Awel y Môr Offshore Wind Farm

Application Errata List

Date: 24 October 2022

Revision: A

FIGURE NUMBER:
Figure 1

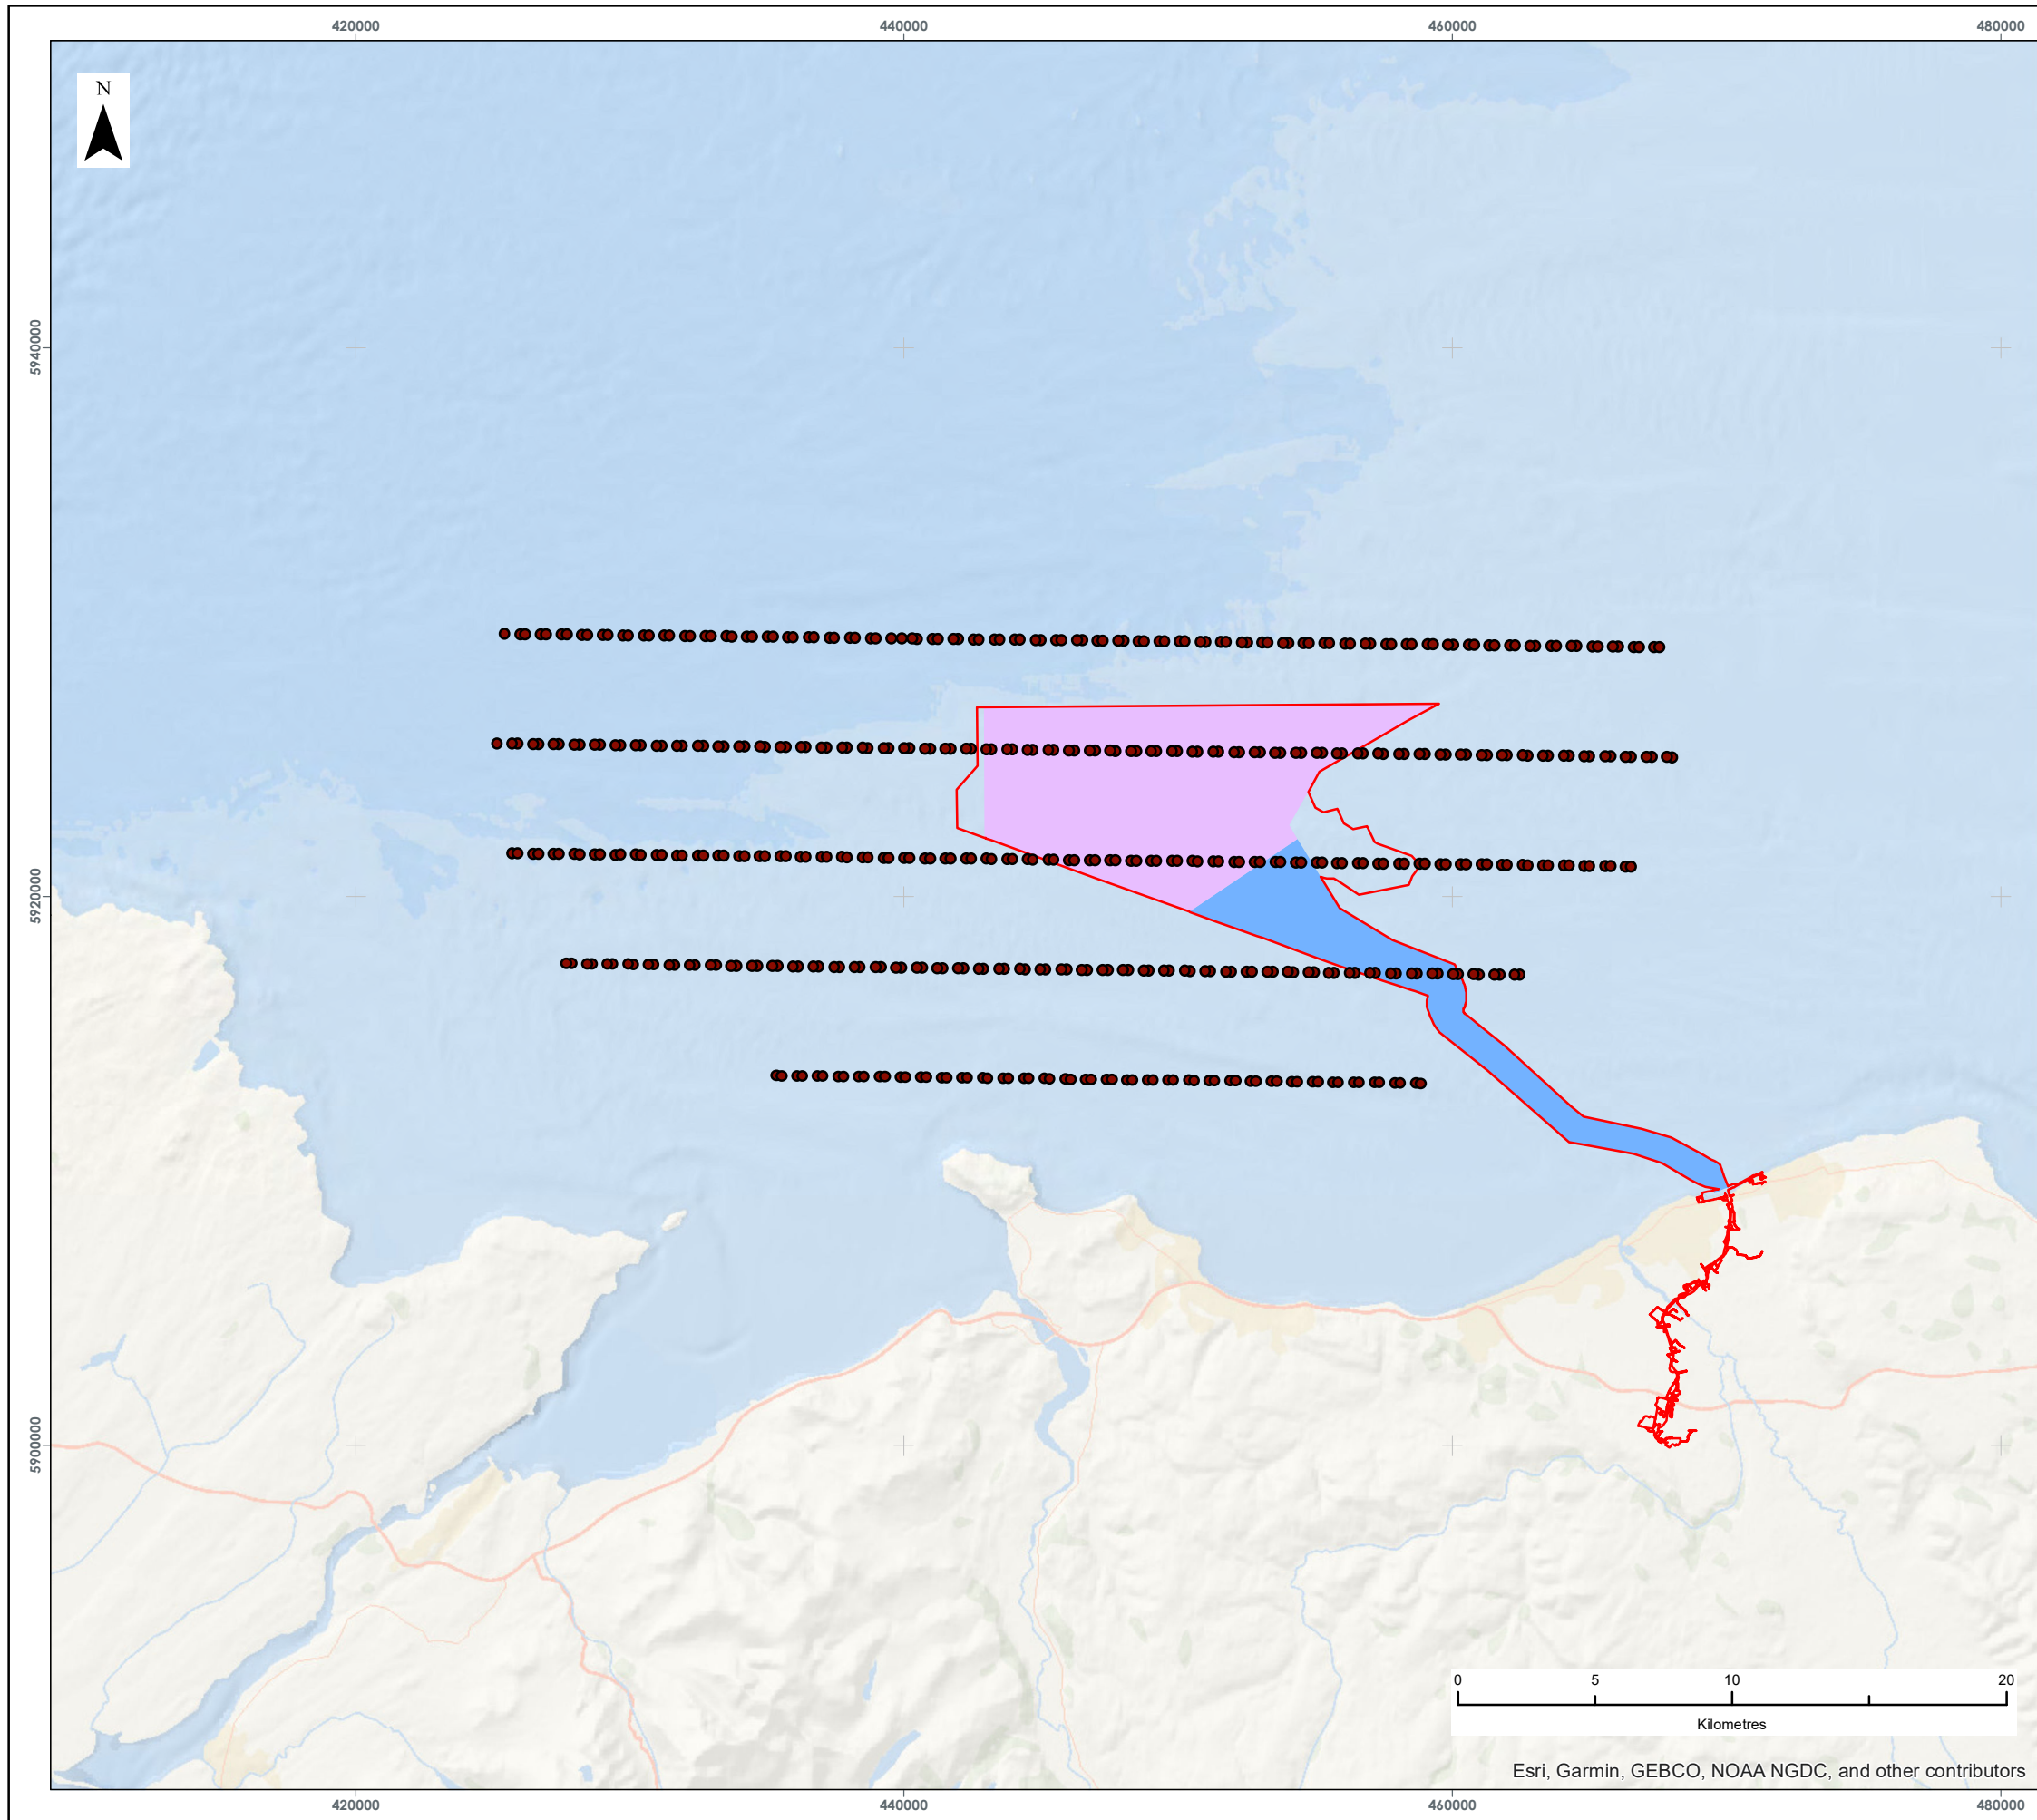
- 7 For completeness, the correct figures are appended to this document in Appendix A, duplicated from the figures presented in APP-053:
 - ✦ Figure 1: Figure incorrectly displayed a black background and omitted base mapping. Corrected figure provided in Appendix A of this document. Note this figure is identical to Figure 1 presented in APP-053.

FIGURE NUMBER:
Figure 2

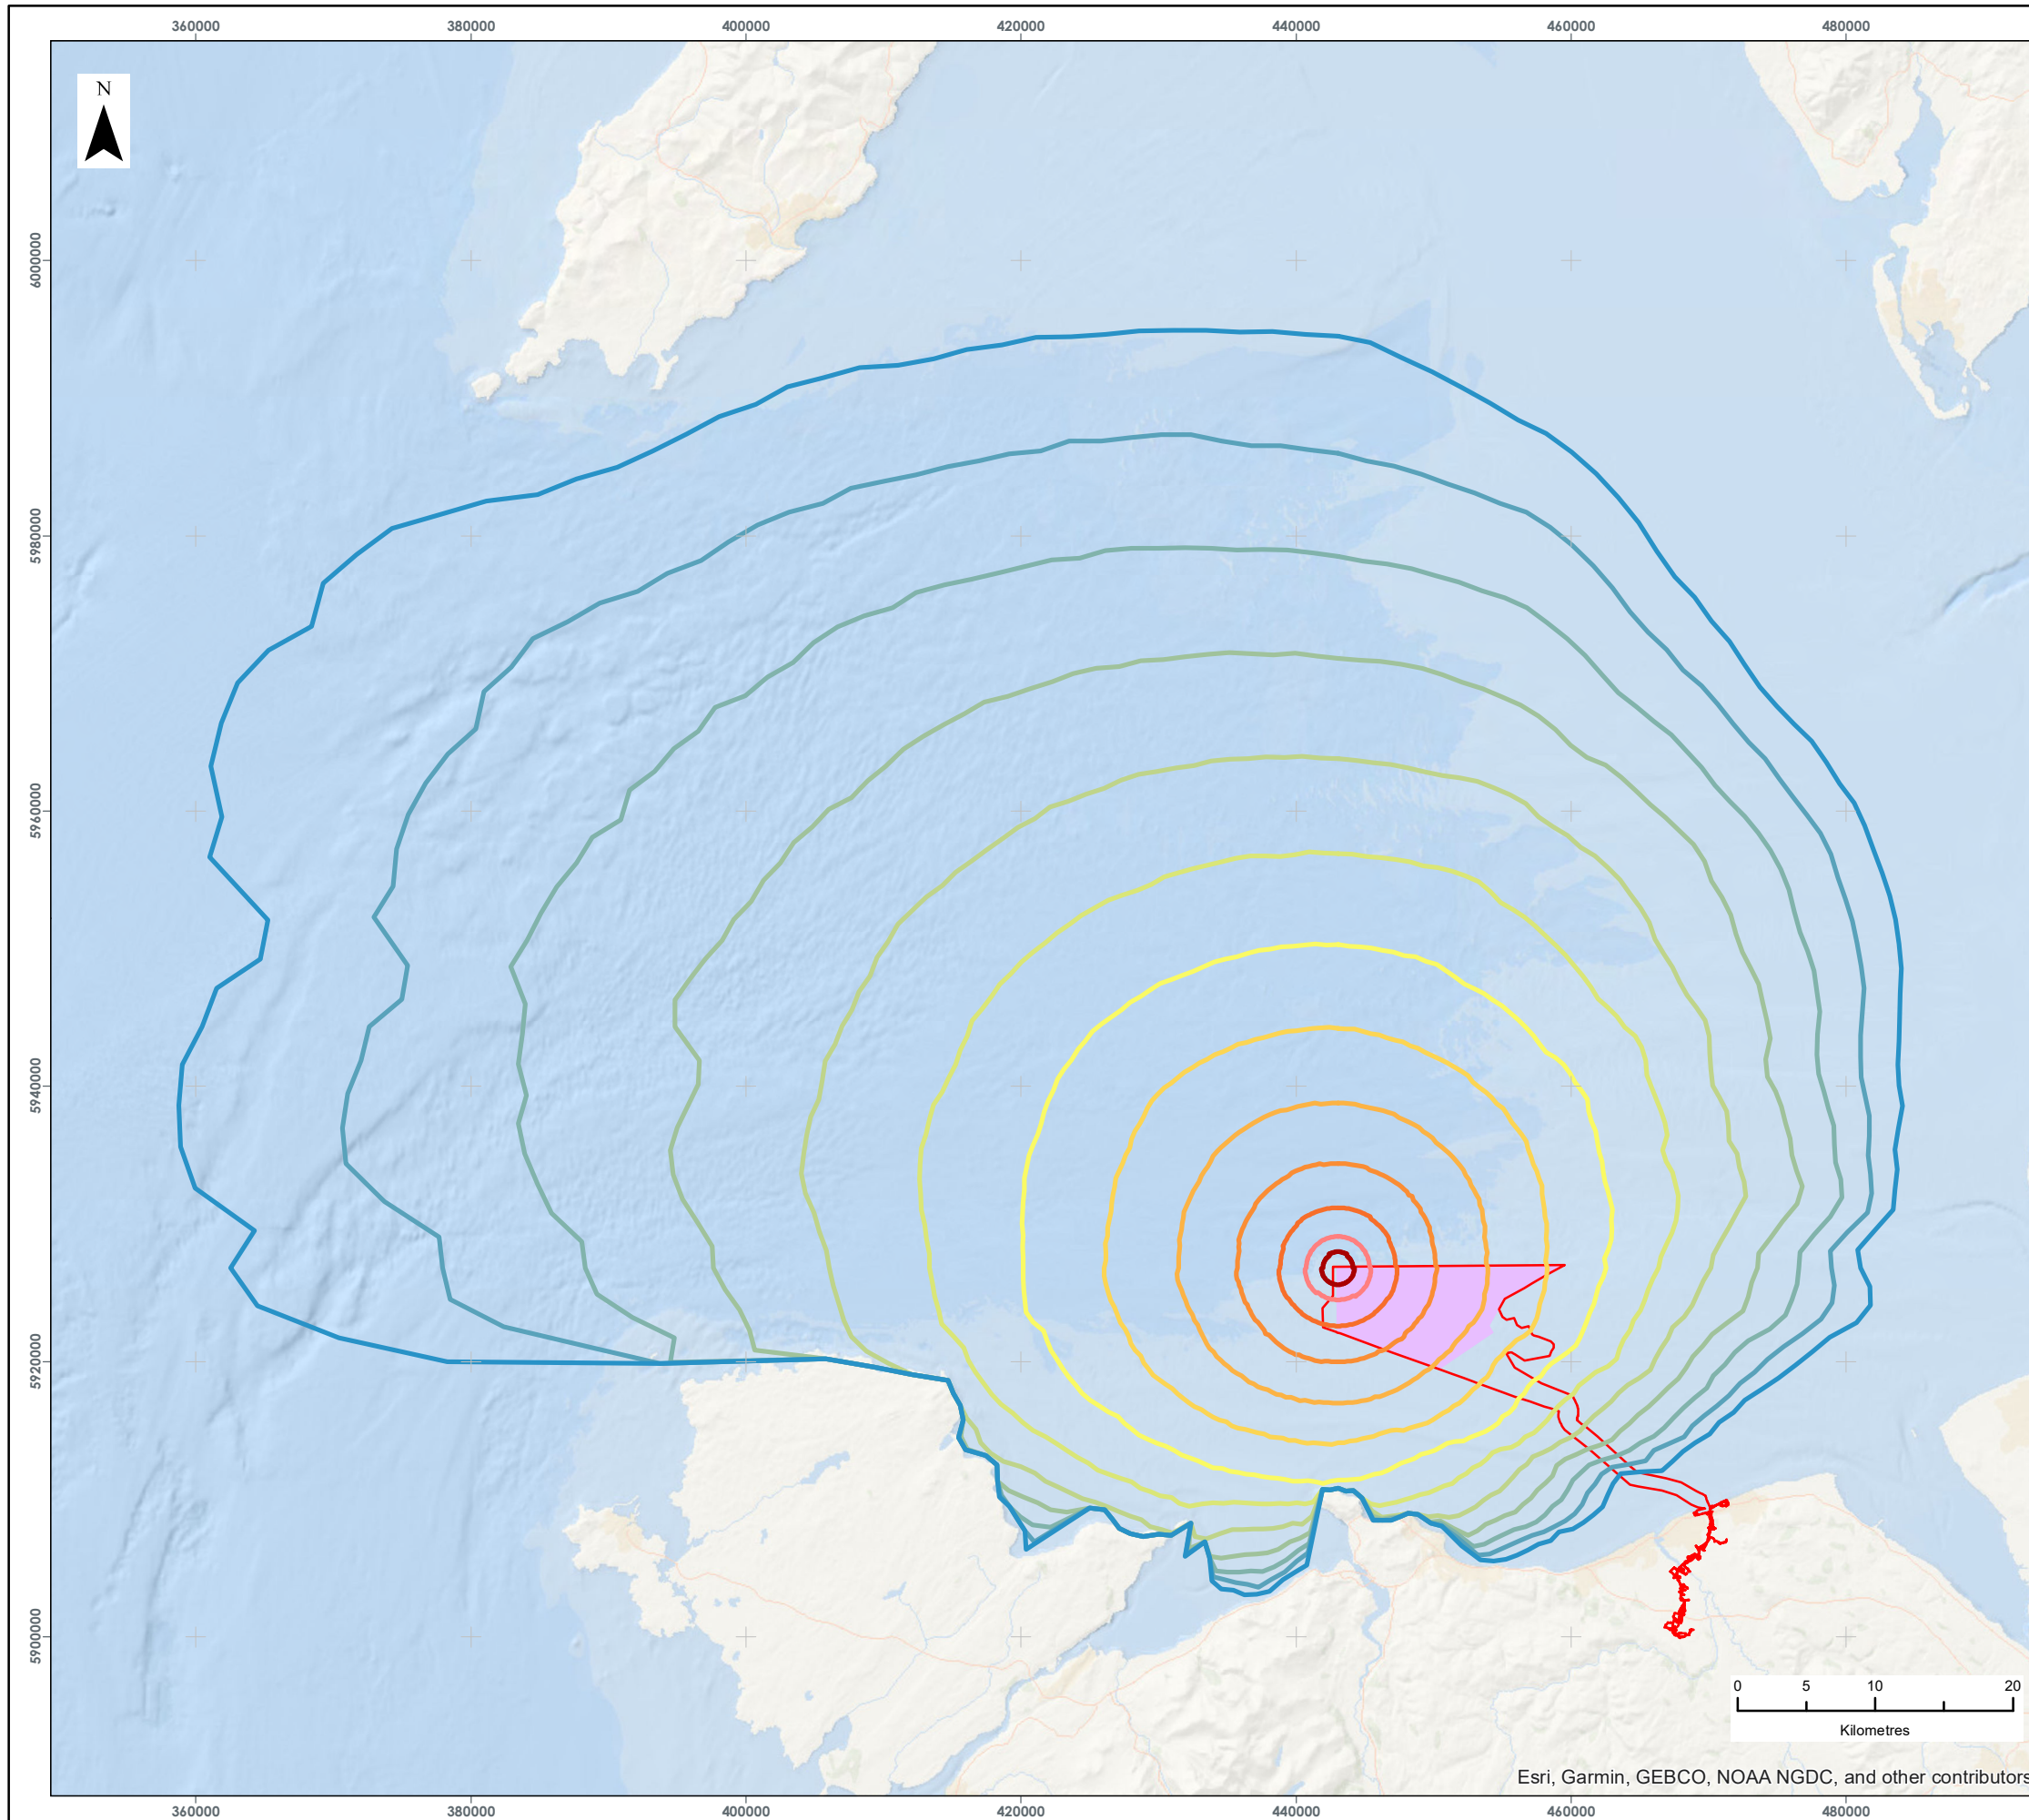
- ▲ Figure 2: Figure incorrectly displayed a black background and omitted base mapping. Corrected figure provided in Appendix A of this document. Note this figure is identical to Figure 2 presented in APP-053.

FIGURE NUMBER:
Figure 18

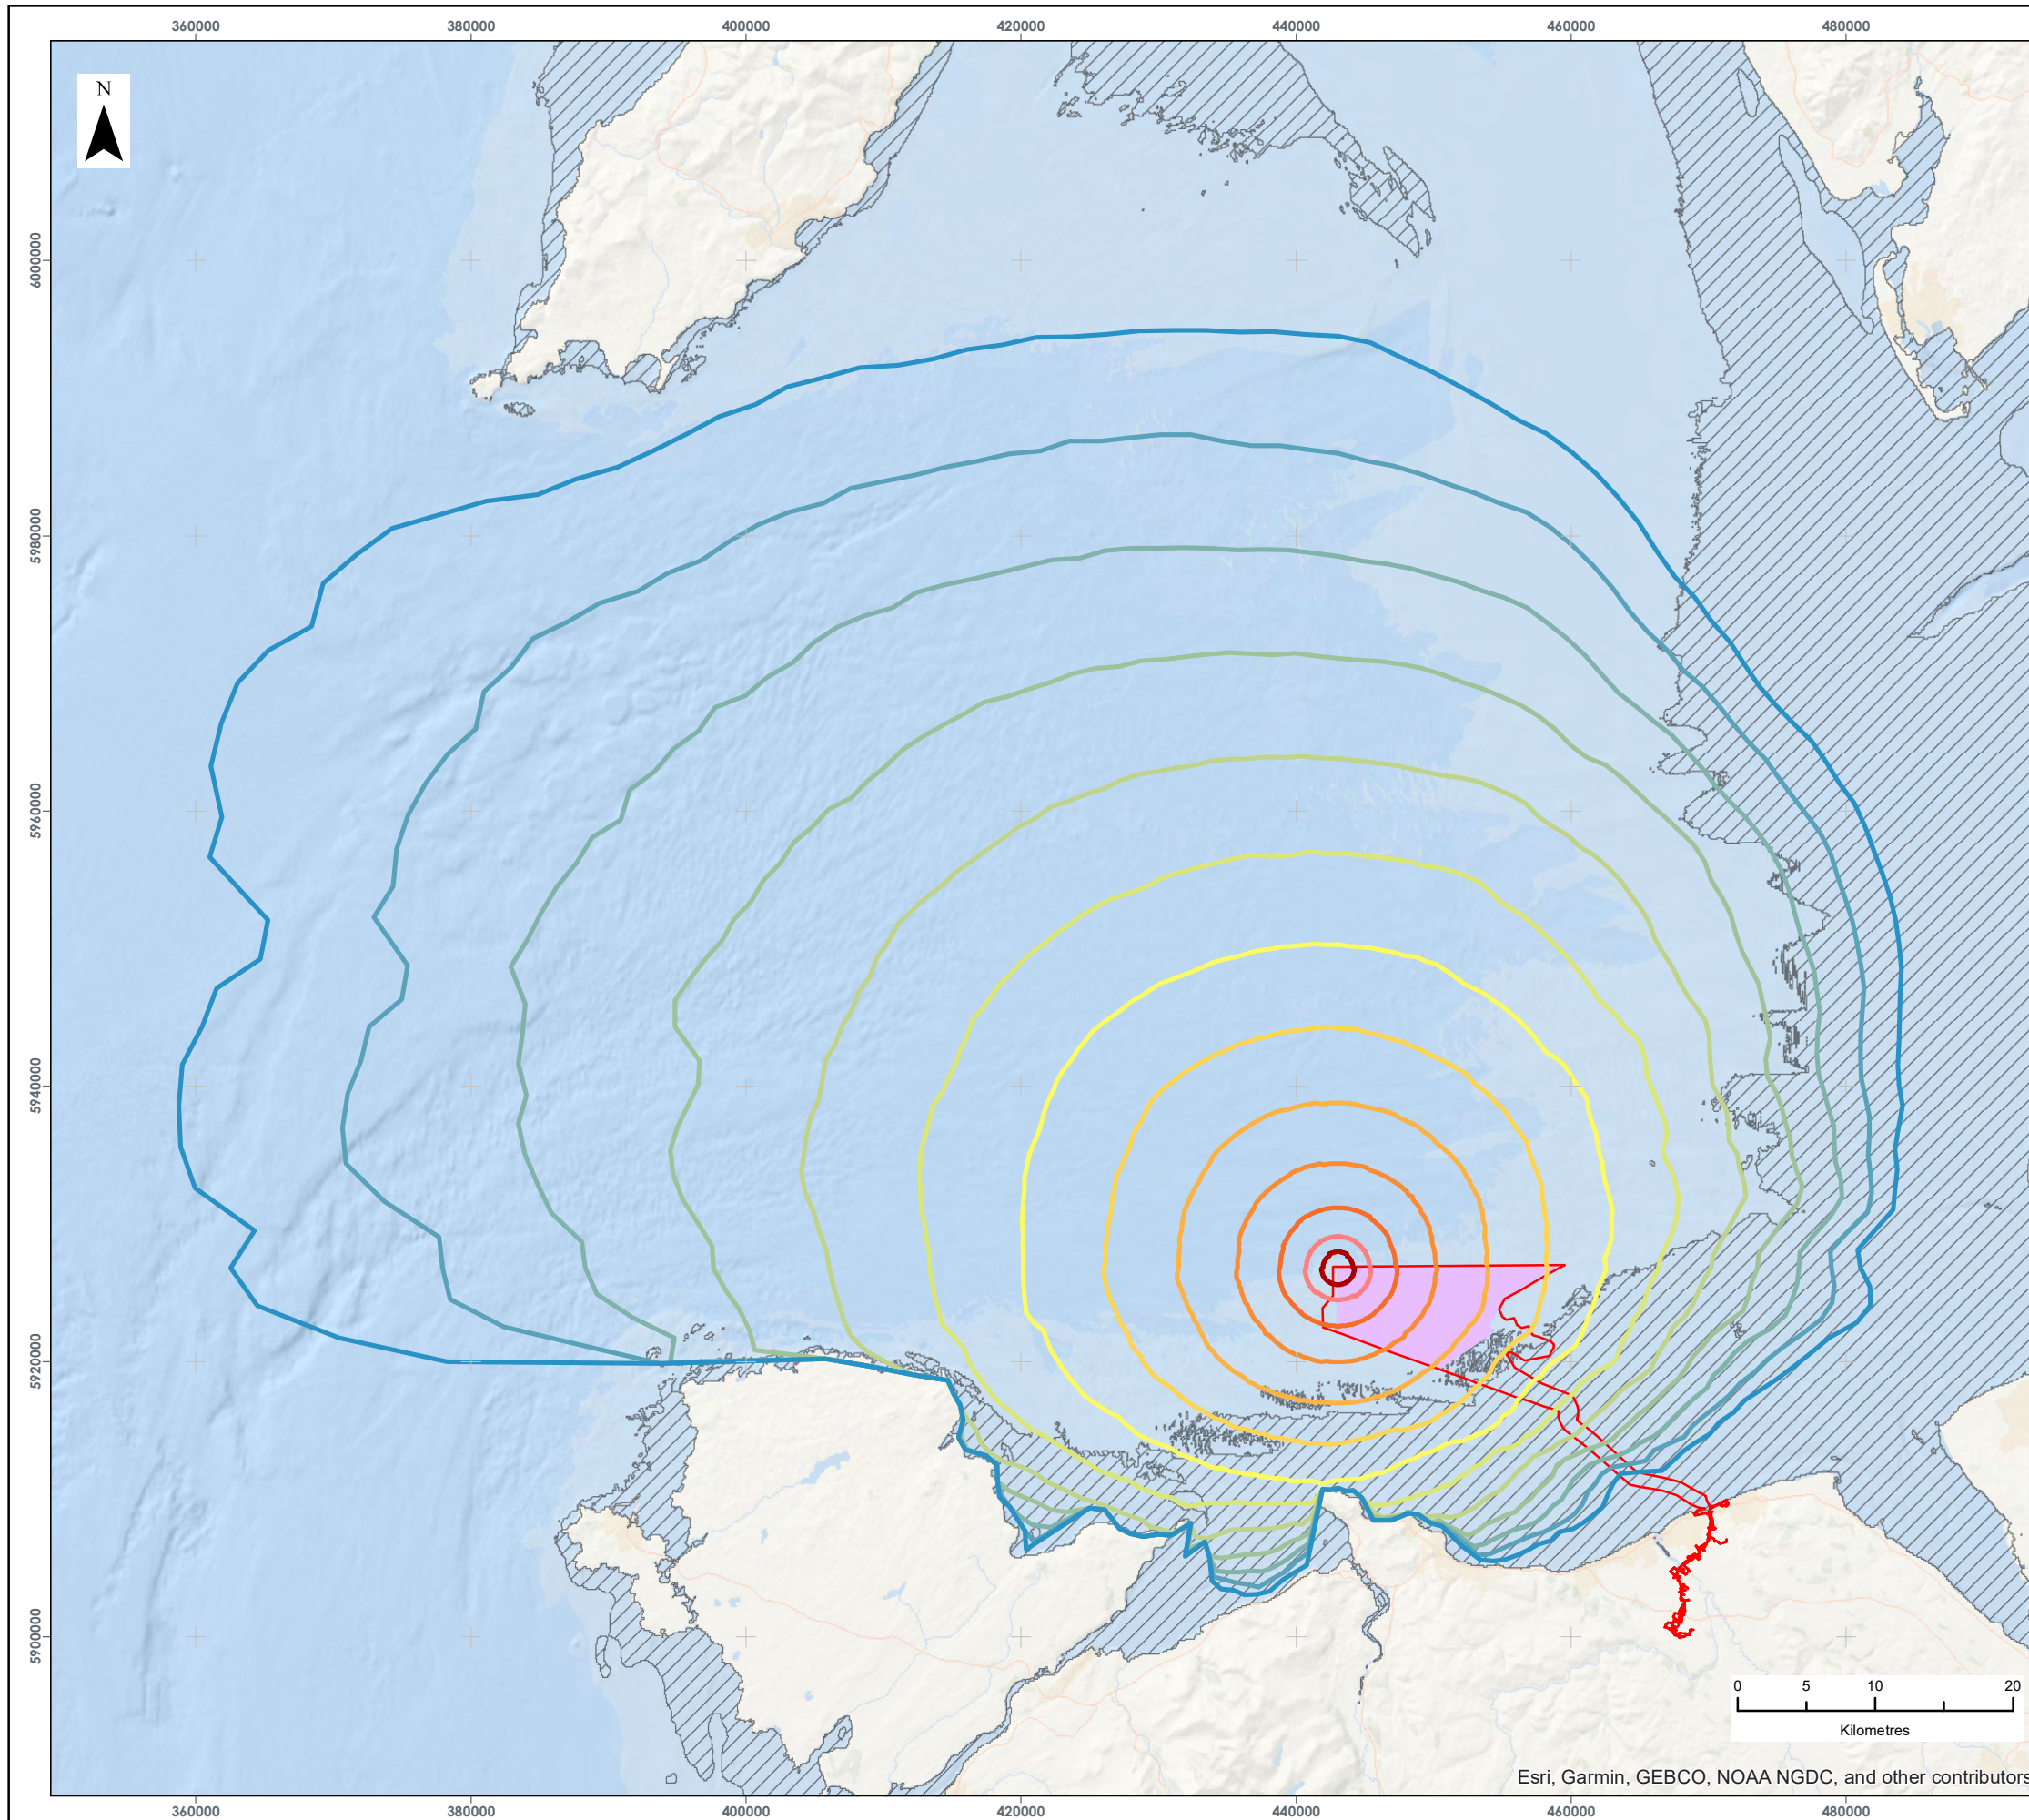
- ▲ Figure 18: Figure incorrectly displayed a partial black background and omitted base mapping. Corrected figure provided in Appendix A of this document. Note this figure is identical to Figure 18 presented in APP-053.
